Environmental Assessment Exhibition (Epping Park) - MP 08_0257 and MP 08_0258

Thank you for the opportunity to provide input on the Environmental Assessment for the Major Project Applications (MP 08_0257 stage 1, residential development and MP 08_0258 Early Works Package) as submitted by the Sydney Broadcast Property Pty Ltd at 61 Mobs Lane, Epping.

The External works plans for Mobbs Lane (Drawing 7587-PA-21 to 7587 – PA-25) has been assessed based on current and potential operations of State Transit, design detail and general comments have been provided:

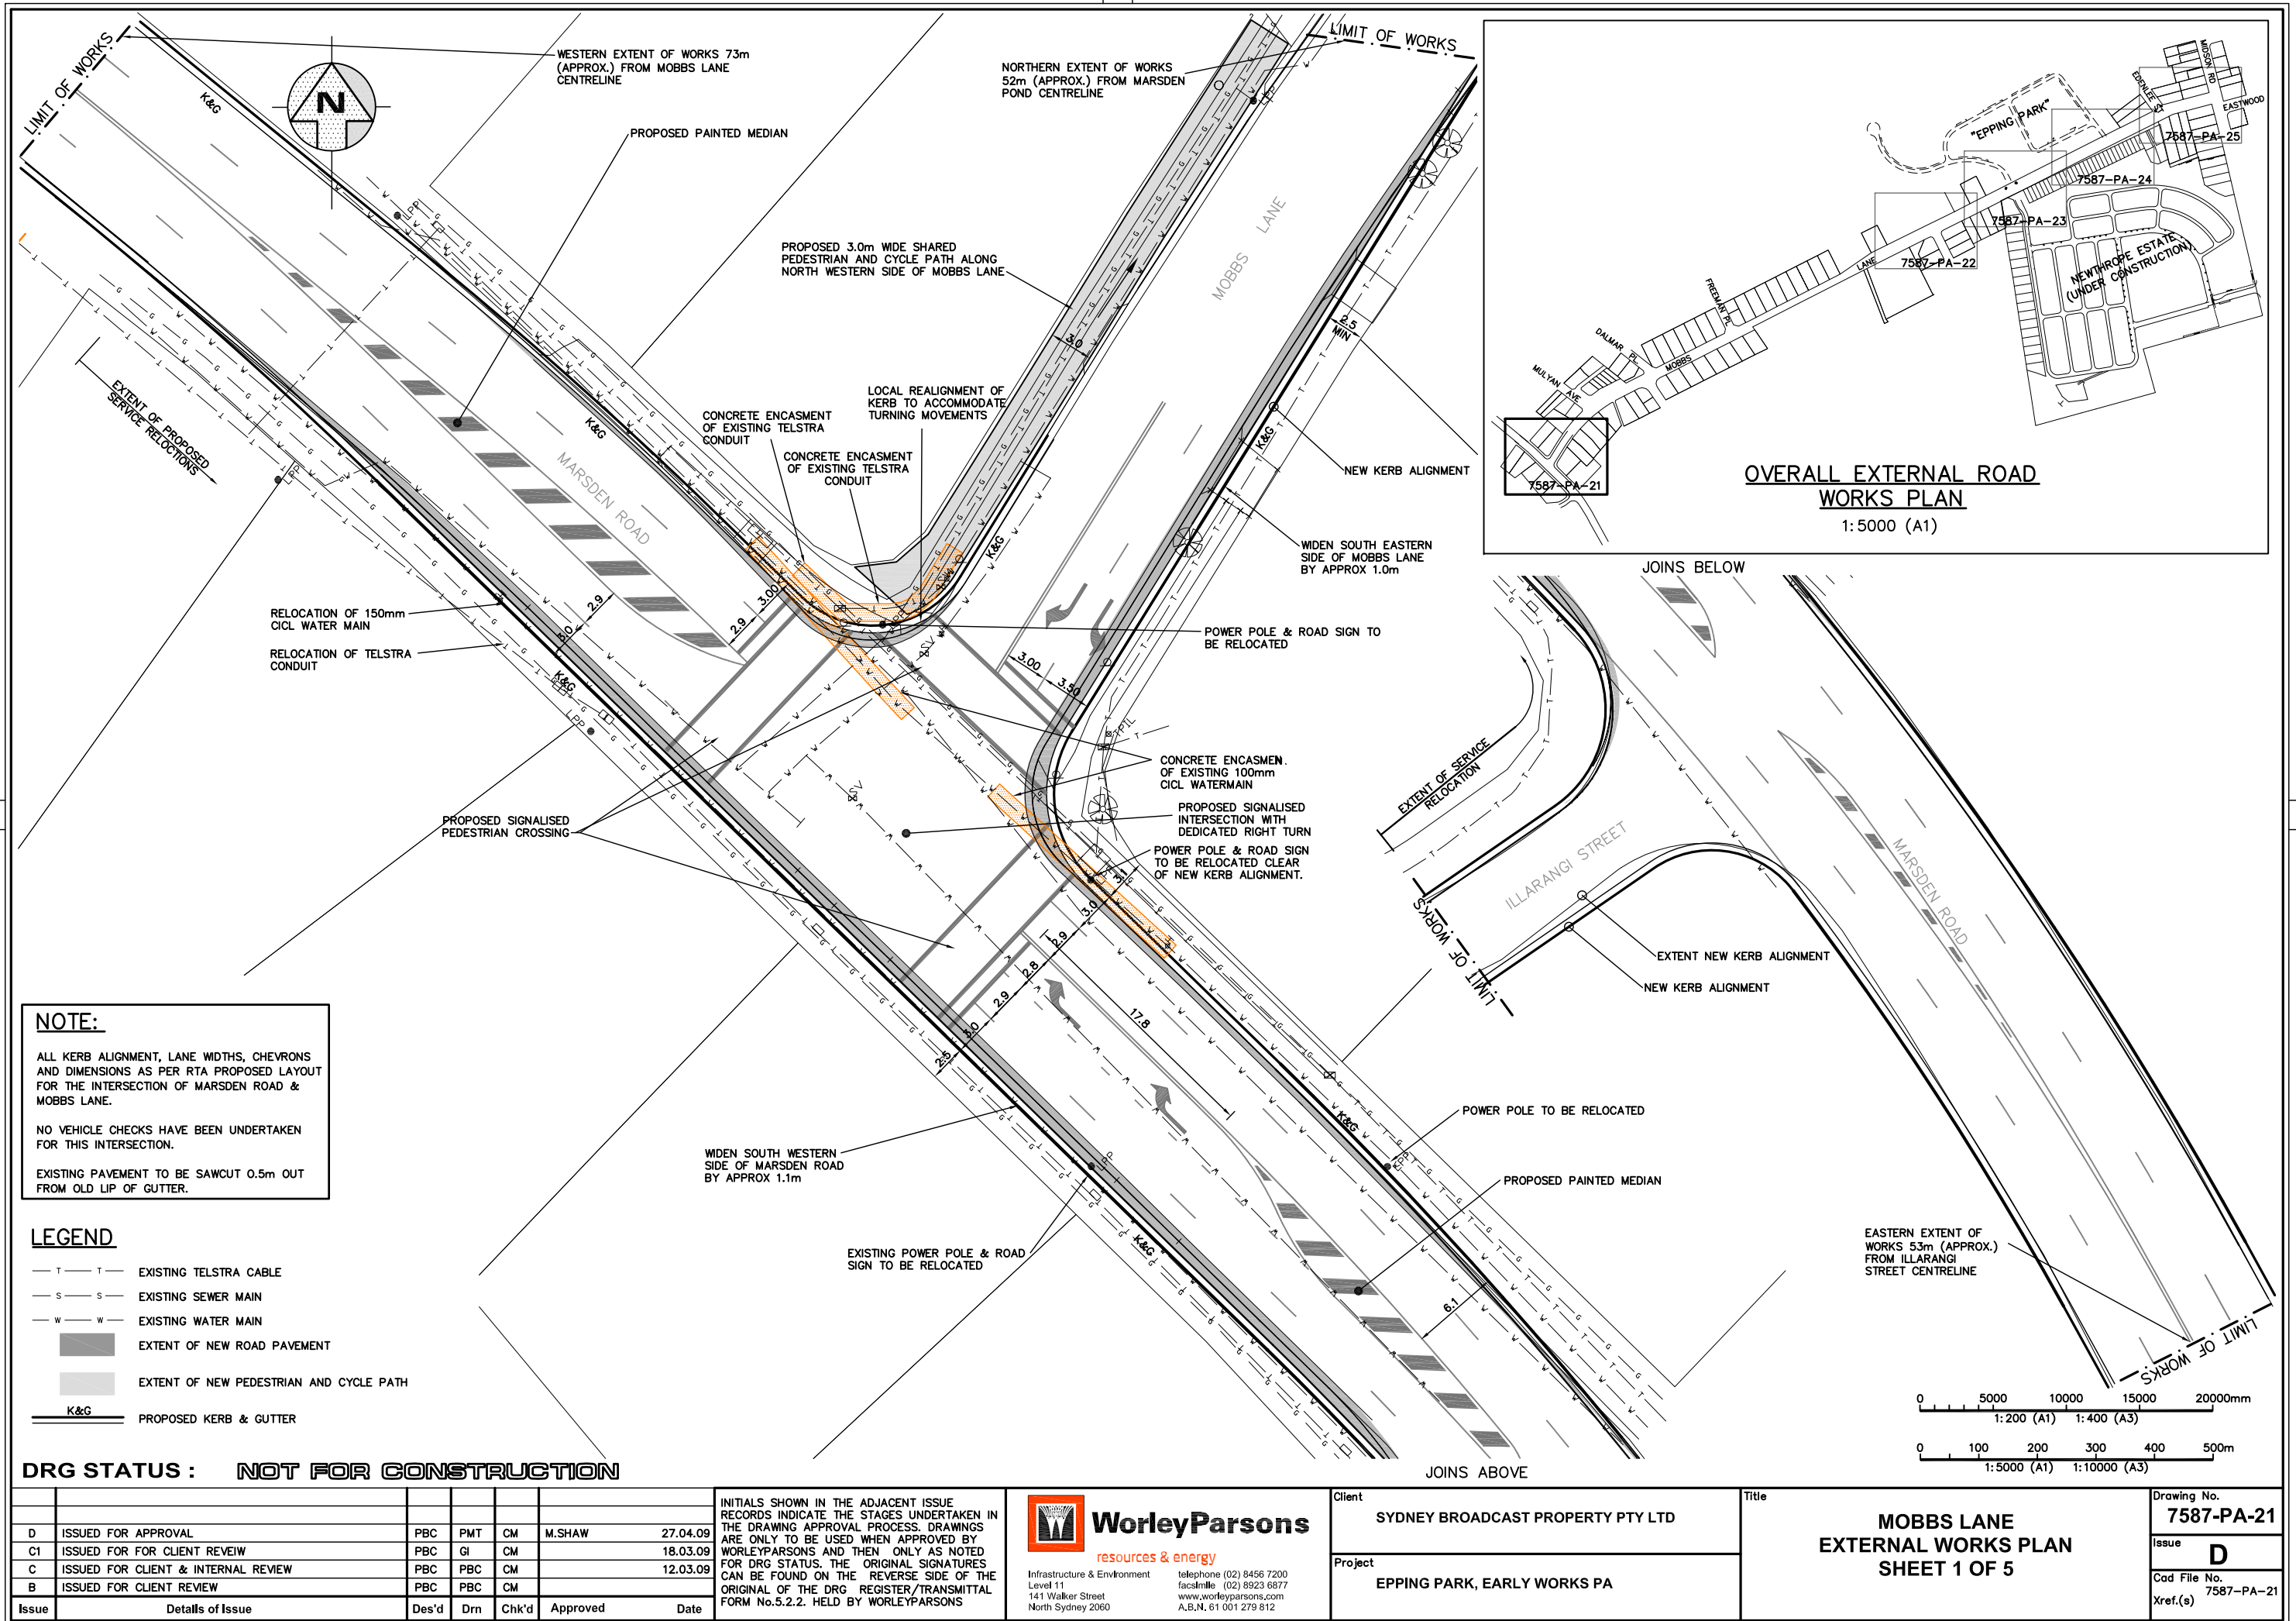
- Drawing Number (7587-PA-21). Proposed right turn bay from Marsden Road to Mobbs Lane, is shown as 17.8 metres. This length does not provided sufficient storage space for both medium vehicles and cars. This will force queuing into the travel lane along Marsden Road. As a minimum the bay should be 40 metres. This has been calculated on the traffic signals not allowing filter right turns and assuming roughly that traffic signals will operate around a 2-minute cycle. As such, this equates to 6 vehicles per cycle, which will require 40 metres of storage.

- Drawing Number (7587-PA-21). The same right turn bay from Marsden Road into Mobbs Lane has a lane width of 2.8 metres. A standard bus has a 2.55 m wide body with 600 mm mirror extrusion; this amounts to a vehicle width of 3.1 metres in a lane of 2.8. The accident potential is further increased with a passing lane of 2.9 m, this section of roads is to narrow and alterations need to be made to the carriageway widths to ensure the safety of all road users. Ideally, the right turn bay should be an absolute minimum of 3.2 metres, which should not compromise other travel lanes.

- Drawing Number (7587-PA-21). Assessment using AustRoad turning templates has determined that buses will have to lane share in order to make the left turn from Mobbs Lane into Marsden Road. This is not an acceptable arrangement, given the amount of traffic generated through this intersection from the development site and if not done, buses will either block traffic turning right or be blocked by traffic turning right. Problems are also present with the right turn into Mobbs Lane.

The intersection be redesigned to ensure buses can turn from within its own lane, using the 12.5 metre bus at 5 – 15 km/h with a turning radius of 15 m. Note the turning template for 5 km/h mandatory stop is not adequate. If these changes are not implemented, then bus services may not be able to use Mobbs Lane.

Drawing No.	7587-PA-22
Issue	D
Cad File No.	7587-PA-21
Xref(s)

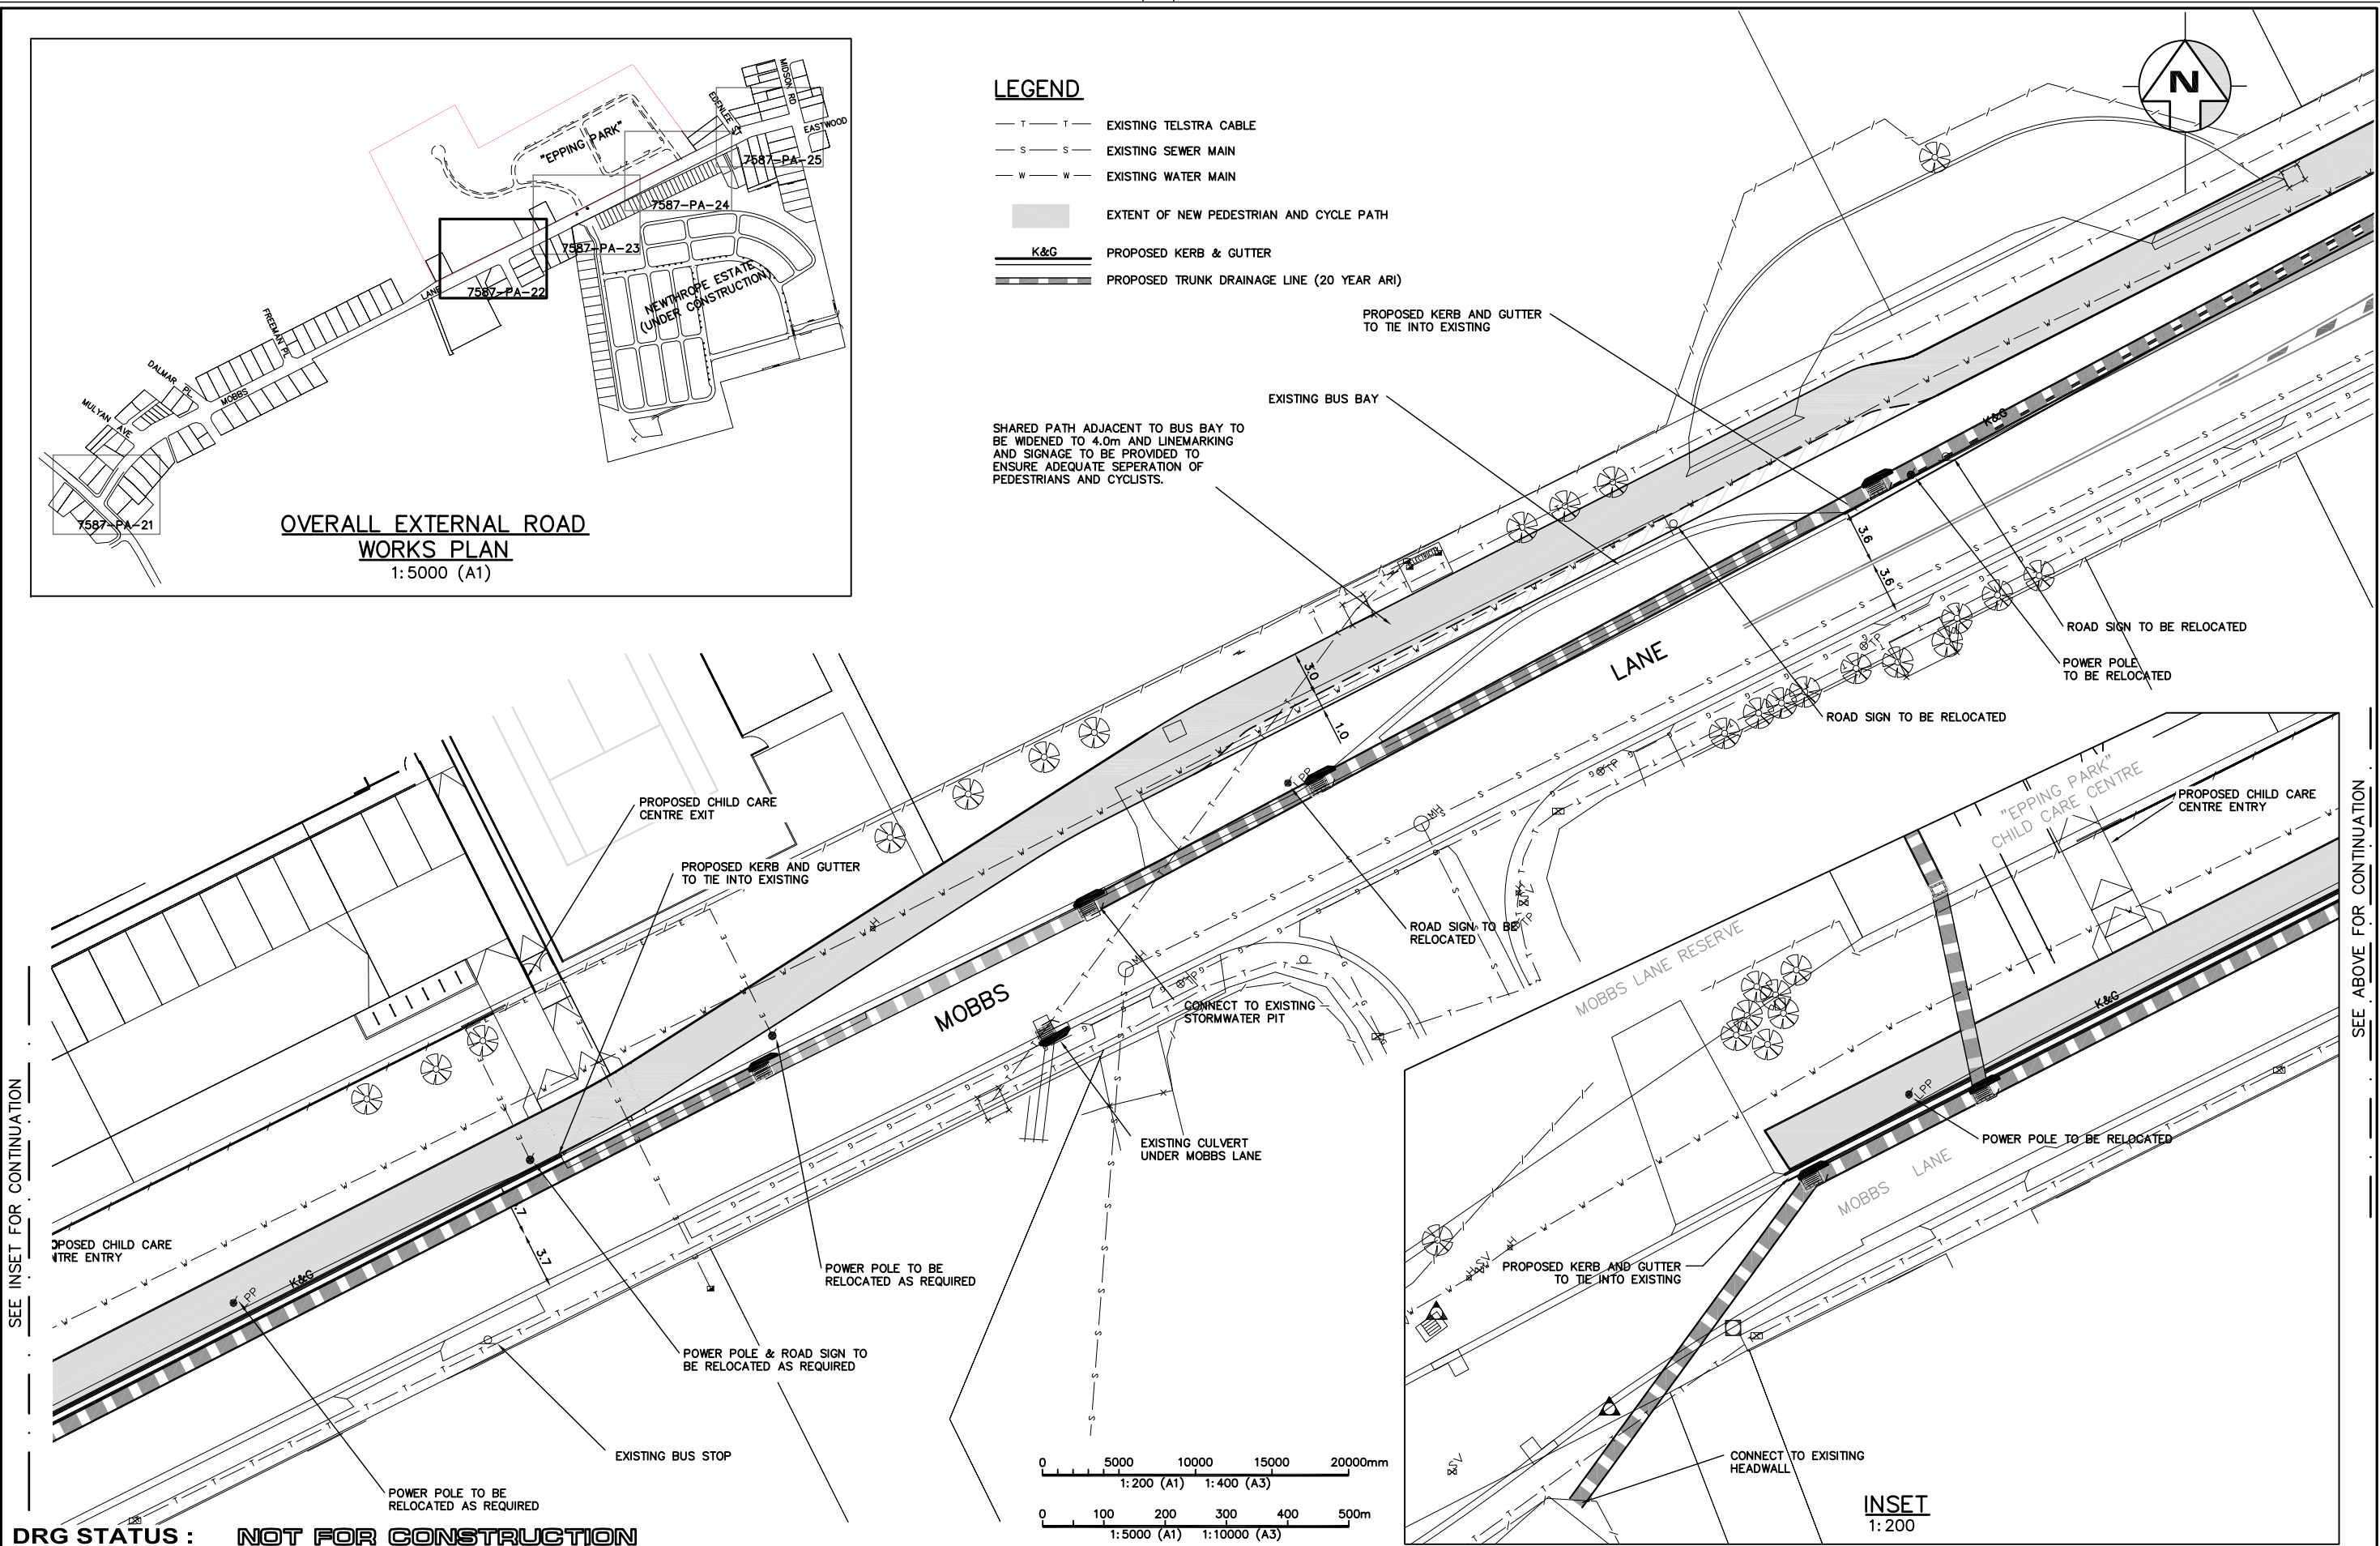
- Drawing Number (7587-PA-22). The bus bay to the east of the childcare centre is shown as been retained as existing. The current design allows for thirty metres, which is required but the barrier kerb where the bus needs to pull into to allow customers to board and alight needs to be long as the vehicle type using the area. In that regard State Transit smallest vehicle is now 12.5 metres in length.
- Drawing Number (7587-PA-22). The cycle path be clearly delineated for cyclists to go behind the passenger waiting area of the bus stop. This arrangement does not offer sufficient space to provide bus shelters or bus stop information, this could result in reduced demand.
